RE: **Albuquerque School of Excellence Expansion**  
**13201 Lomas NE**  
**Grading and Drainage Plan Stamp Date: 11/20/19**  
**Hydrology File: J22D050**

Based on the submittal received on 11/25/19, the grading and drainage plan is approved for Building Permit.

**RE: ALBUQUERQUE SCHOOL OF EXCELLENCE EXPANSION  
13201 LOMAS NE  
GRADING AND DRAINAGE PLAN STAMP DATE: 11/7/19  
HYDROLOGY FILE: J22D050**

Per your Hydrology Review comments letter dated 11/19/19, please find the following responses addressing your comments listed below:

<b>ABQ SCHOOL OF EXCELLENCE</b> <b>OVERALL GRADING AND DRAINAGE PLAN</b>	DRAWN BY pm DATE 11-5-19 DRAWING 2019068-GR
	TIERRA WEST, LLC 5571 MIDWAY PARK PL NE ALBUQUERQUE, NEW MEXICO 87109 (505) 858-3100 www.tierrawestllc.com	SHEET # <b>GR-1</b> JOB # 2019068

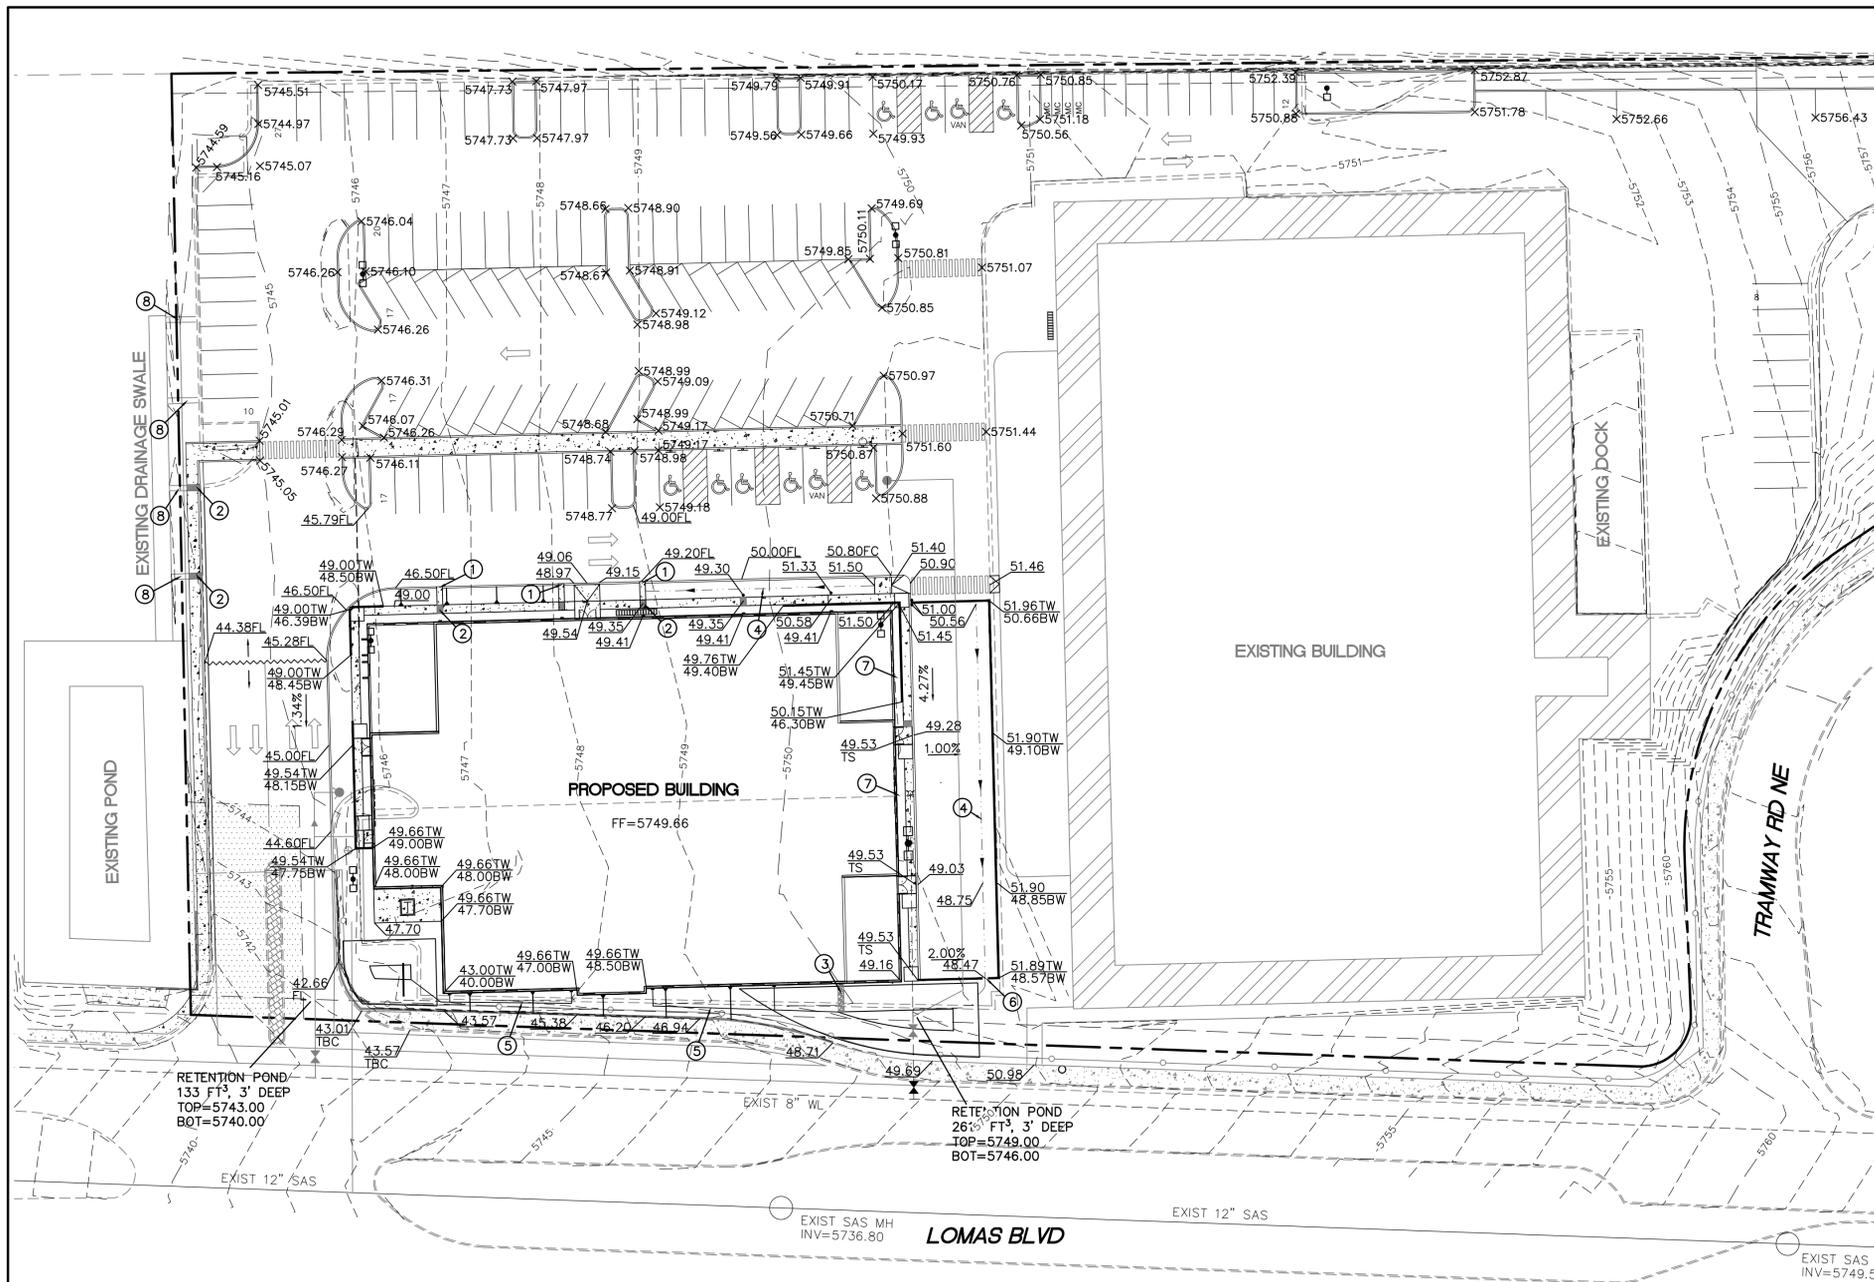
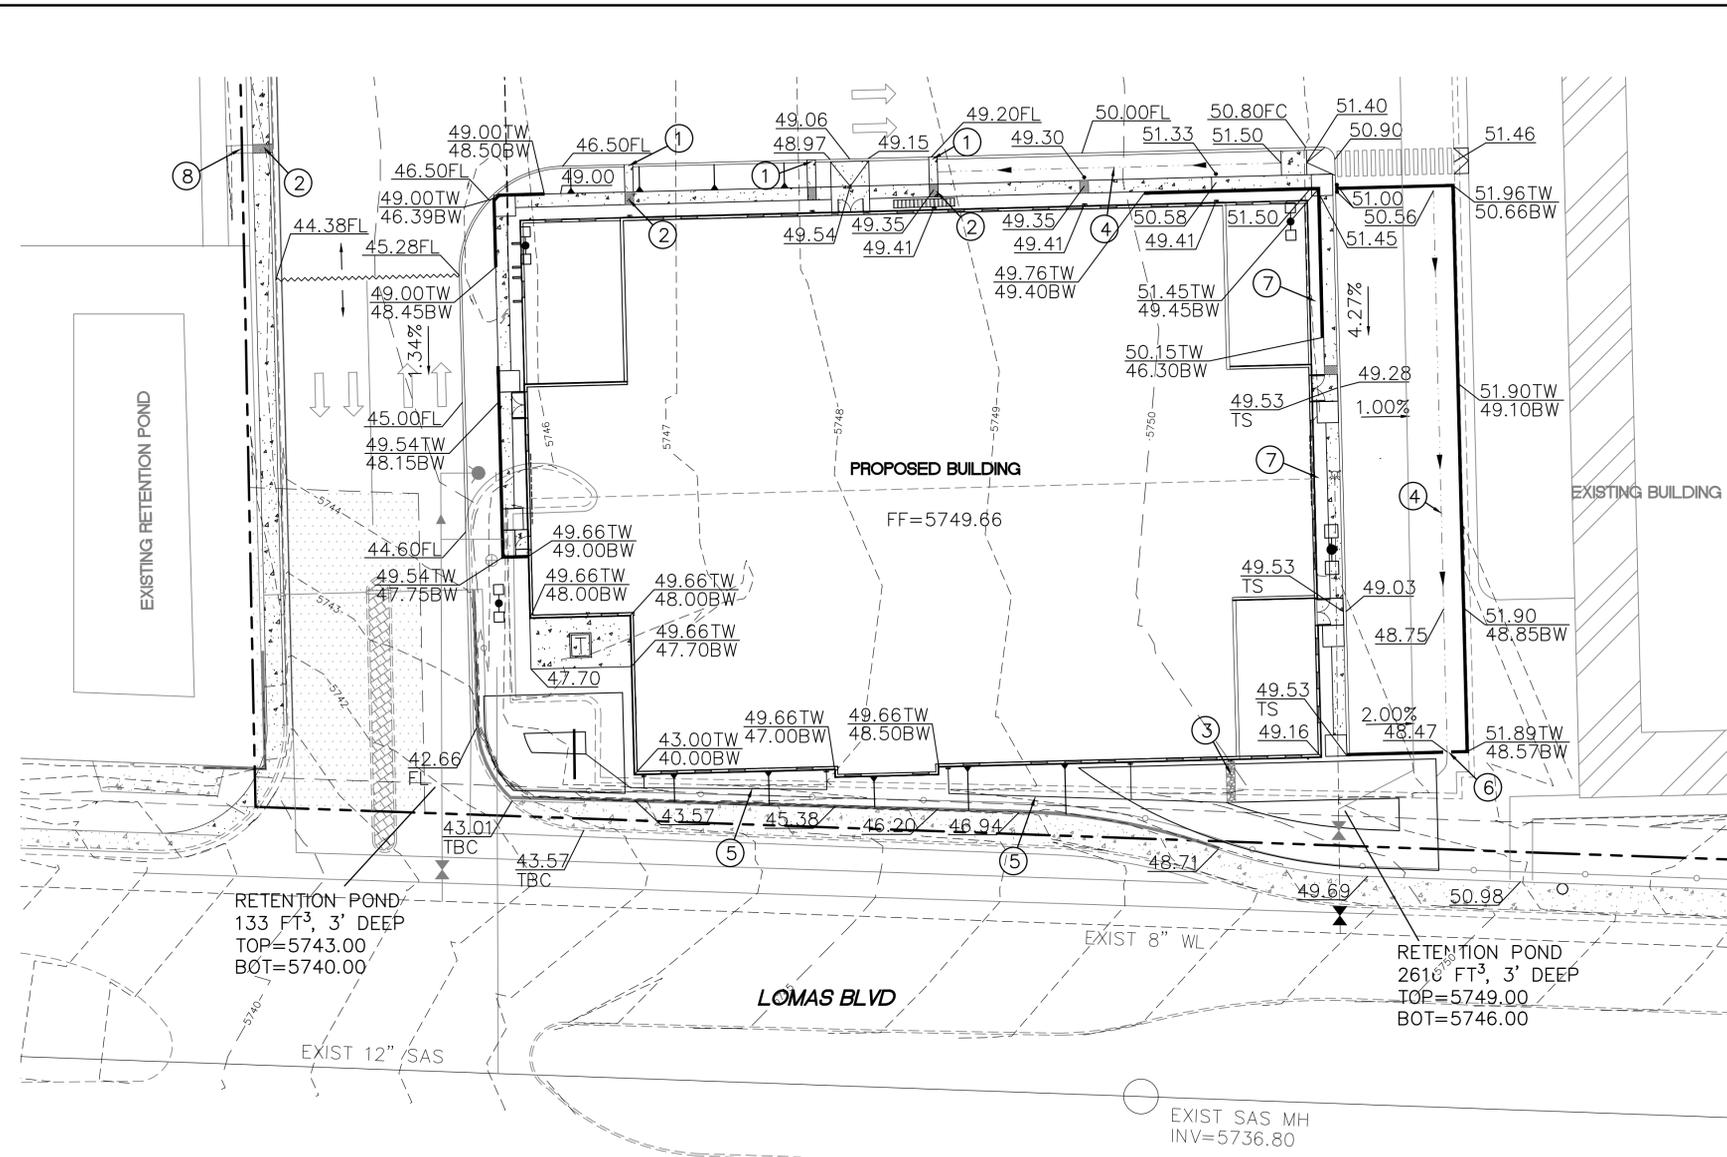
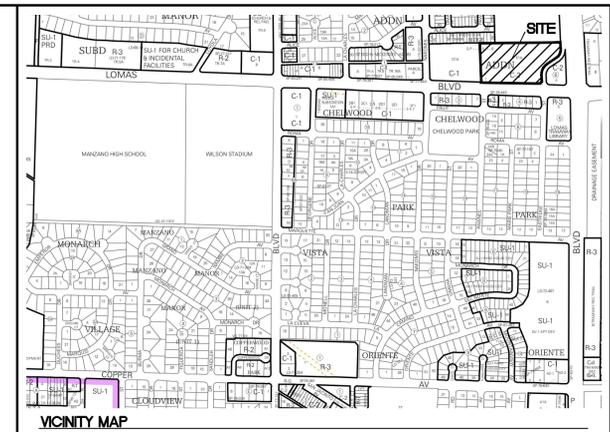
1. Please number the pounds and include sections and labels on each with the Stormwater Quality Volume (SWQV) and elevation, the 100-year volume and elevation, the peak 100 year inflow, top of pond elevation. Provide pond volume calculations by contour area; correct the volume on the western pond.

**The ponds are now labeled and the information is shown on the cross-sections and in the pond volume tables.**
2. Please include the SWQV calculations. This site qualifies as redevelopment and is only required to retain runoff from the 80<sup>th</sup> percentile storm (Vol. = 0.26" \* Imp. Area).

4. Provide a section though the proposed building and Lomas. Provide stabilization of slopes exceeding 3:1. There's one stem wall elevation called out as TW=43.00 that probably should be 49.66.

**The storm water quality volumes are now shown on the Grading Plan.**
3. The eastern (and western) pond cannot encroach on the ROW.  
**The previously submitted plan was showing the boundary line in error which is now correct. Neither pond is encroaching in the right-of-way.**

**Cross-sections were added to the plan and the wall elevations corrected. Slope protection is shown in the cross-sections and called out as crushed cobble 3"-4" in diameter.**
